**From:** Speakman, Glenn - Communities <Glenn.Speakman@Oxfordshire.gov.uk>  
**Sent:** 12 November 2020 12:00  
**To:** Linda Griffiths; DC Support  
**Subject:** 20/02813/DISC - Land South West Of Bicester Adjoining Oxford Road And Middleton Stoney Road Bicester - Partial discharge of condition 34 (service trenches, pipe runs, drains, earth movement) of 06/00967/OUT - (For Parcels KMF & G by Linden Homes)

Drawing Title
Combined Services Plan

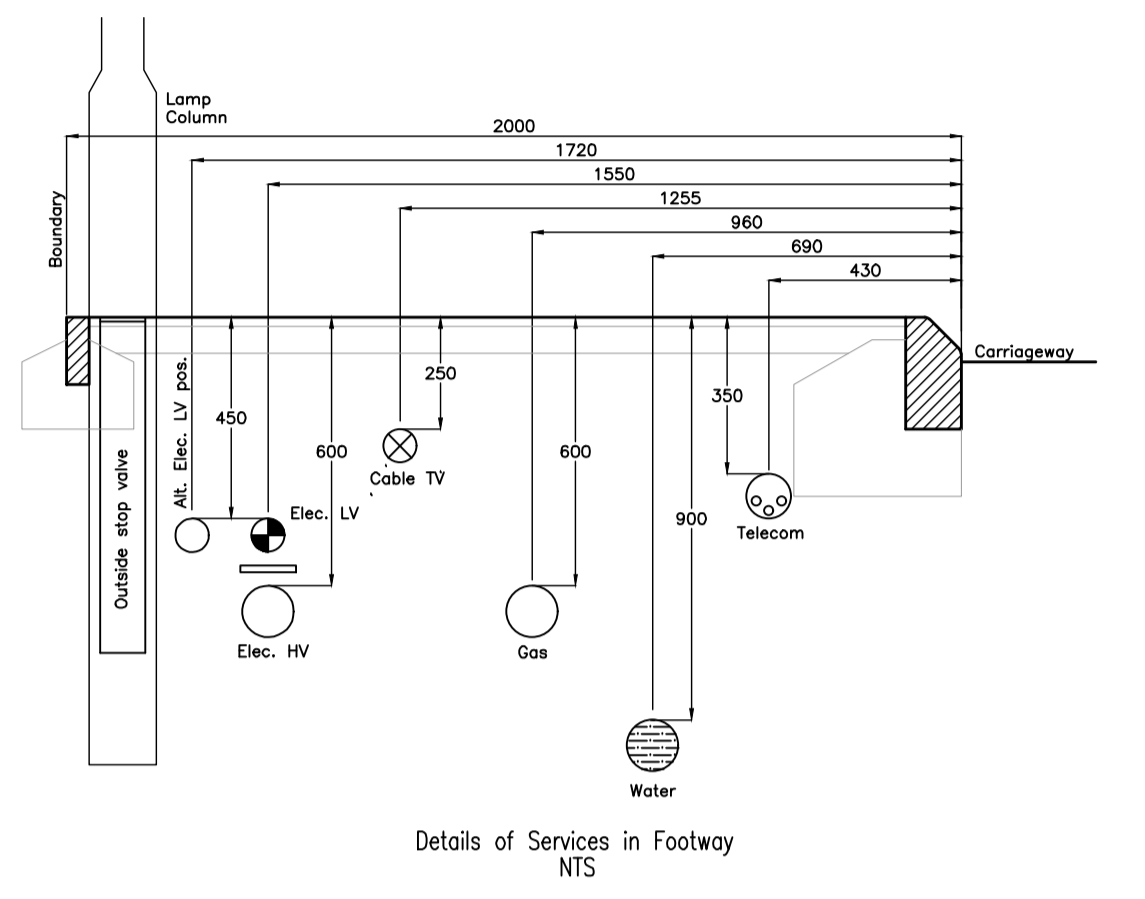
The services are currently shown going through visitor parking bays in the carriageway, services will require dropping in this section to ensure they are outside of the carriageway construction.
